July 29, 2022

City of Mercer Island – Community Planning & Development
Mercer Island, WA 98040

Project: **2205-232-INTAKE1 | ROSS-PARKS RESIDENCE**
7010 93RD AVE SE, Mercer Island, WA 98040

Please accept this letter as a formal response to INTAKE1 notes, dated June 15, 2022 to the residential remodel & addition Application, submitted May 12, 2022. My hope is that we have addressed all comments, and that your application review may continue.

A4.0

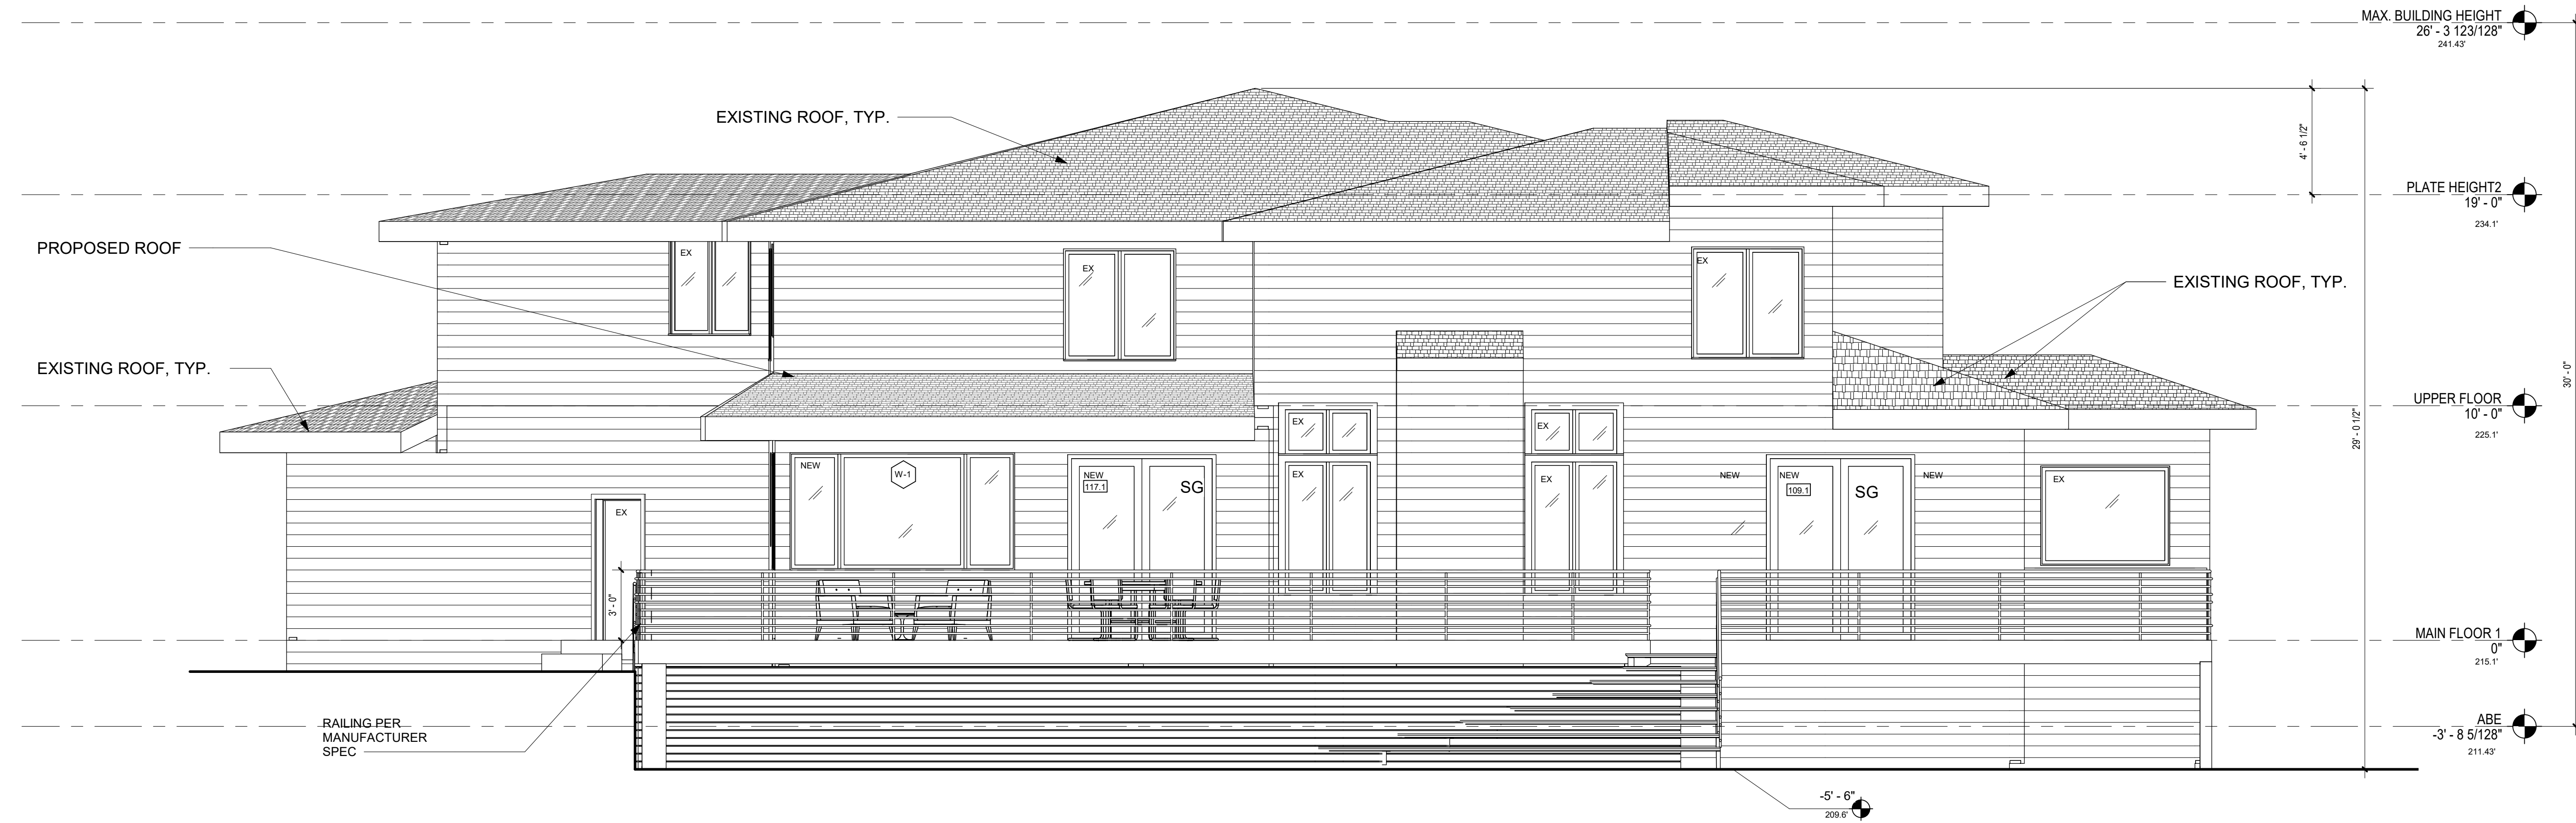
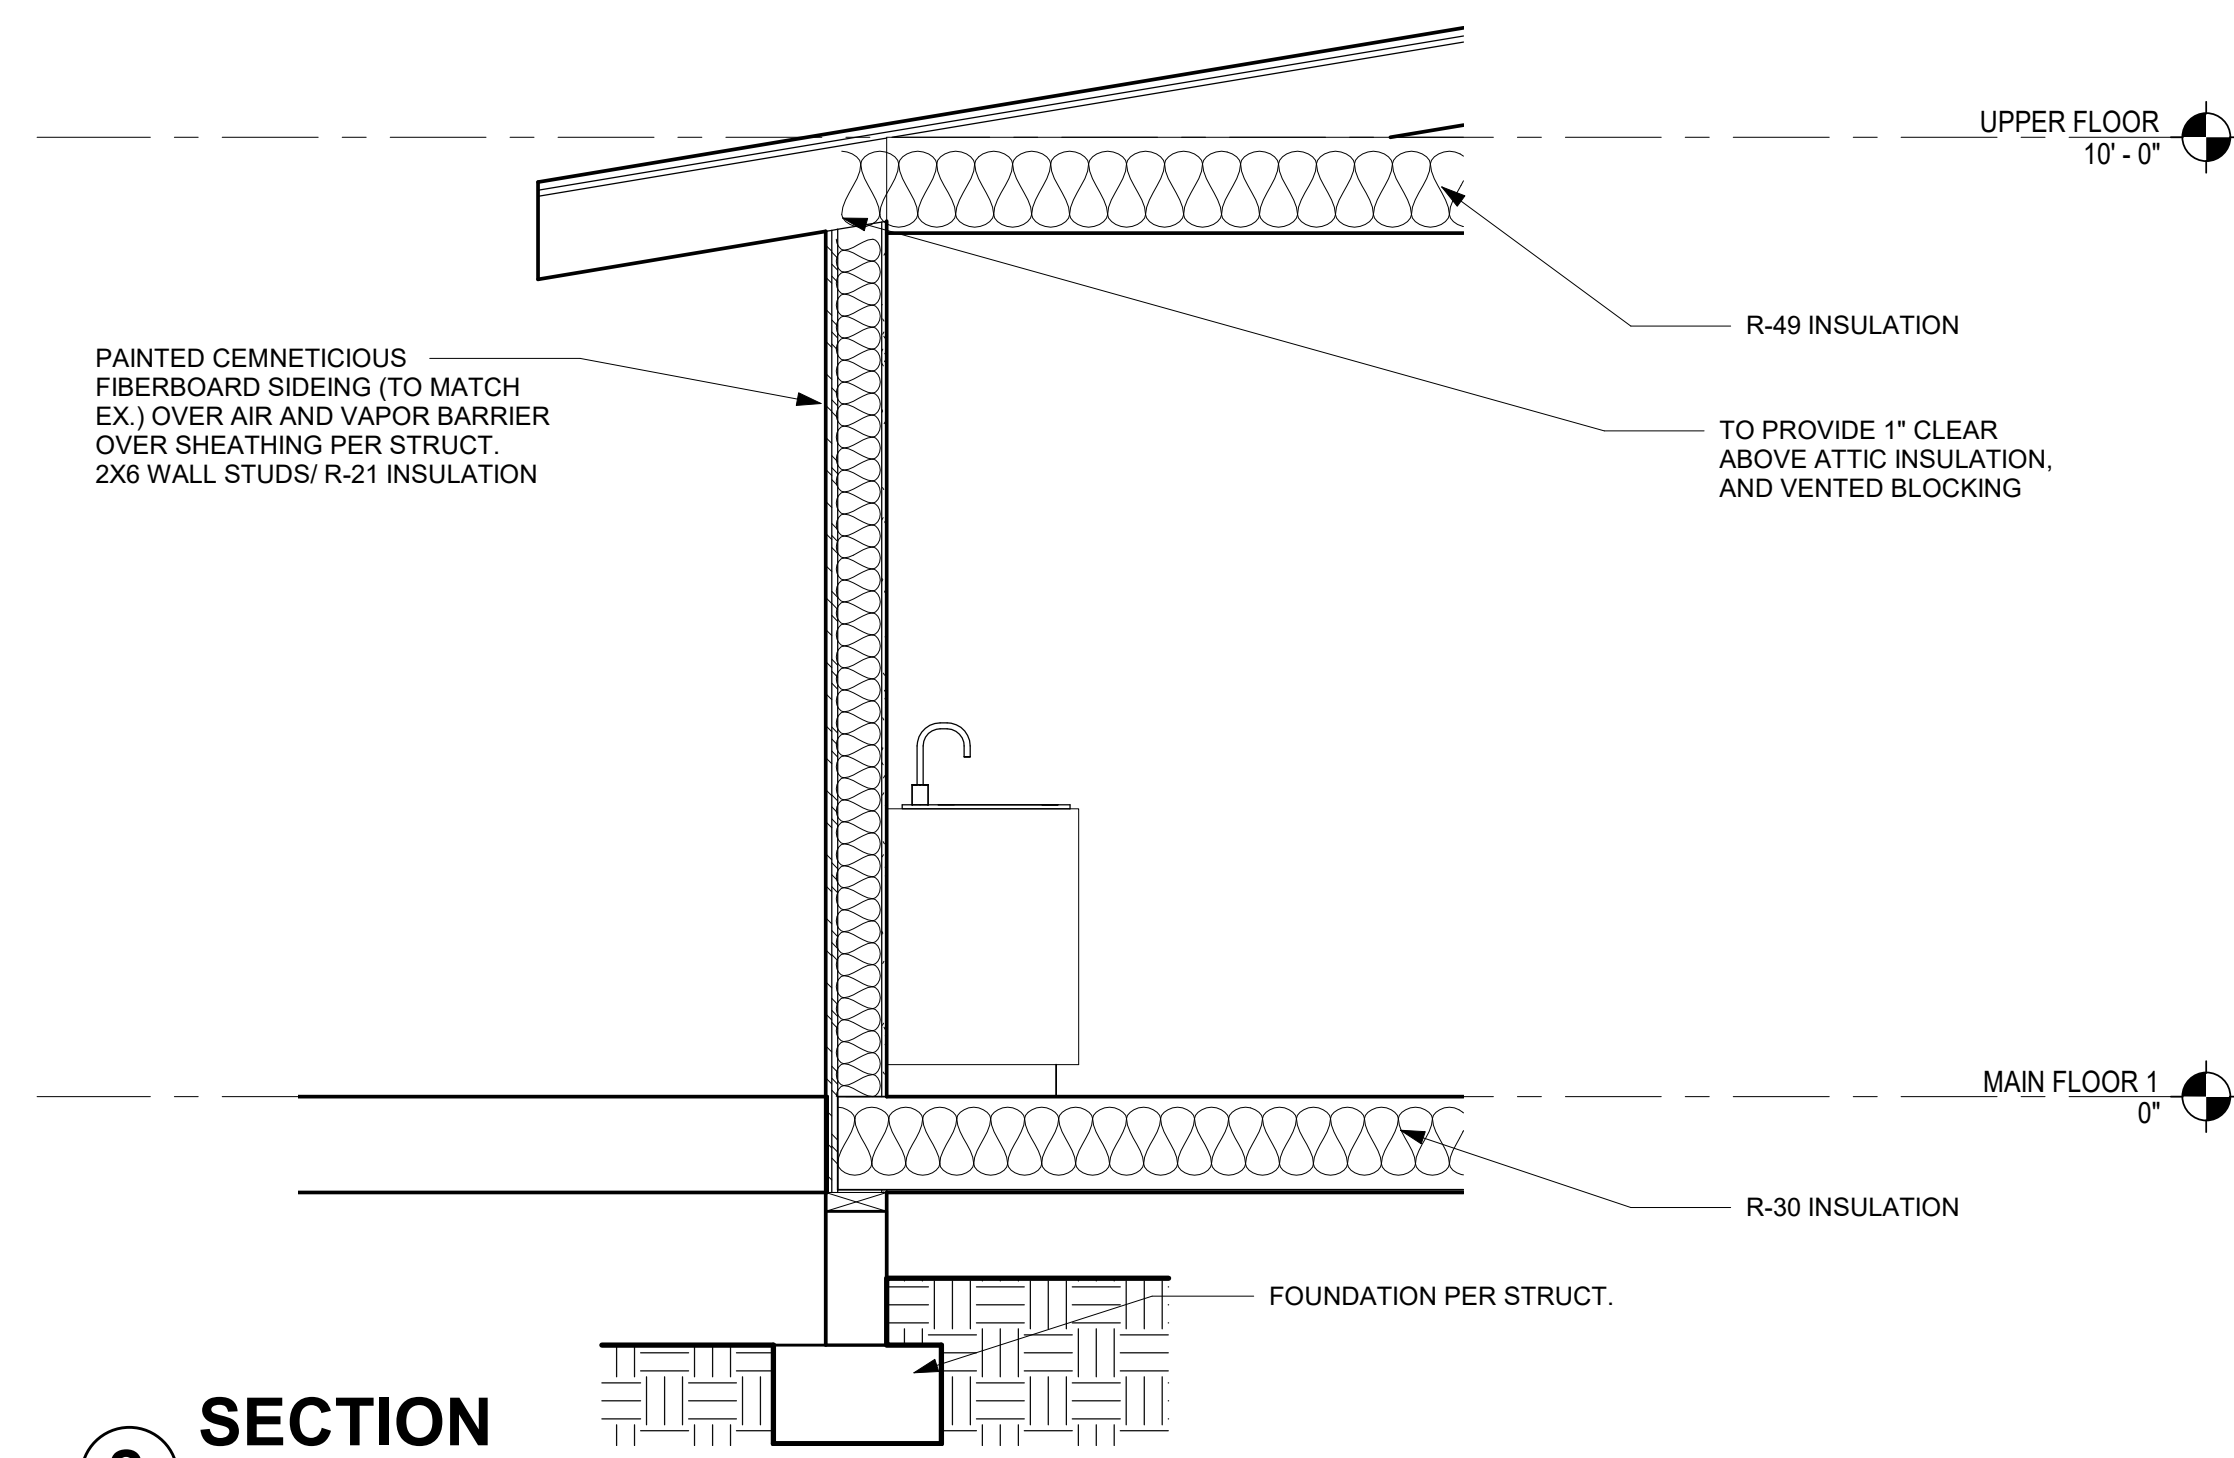
- Please show and label the existing grade, finished grade, proposed building height, maximum allowed building height, maximum downhill facade height, and average building elevation on all elevation drawings. Please also provide calculations for the average building elevation.
 - ABE& Max. building height calculation has been added to sheet A0.0
 - ABE& Max. building height has been added to sheet A4.0
 - All the Existing & finished grade labels have been added to sheet A1.0
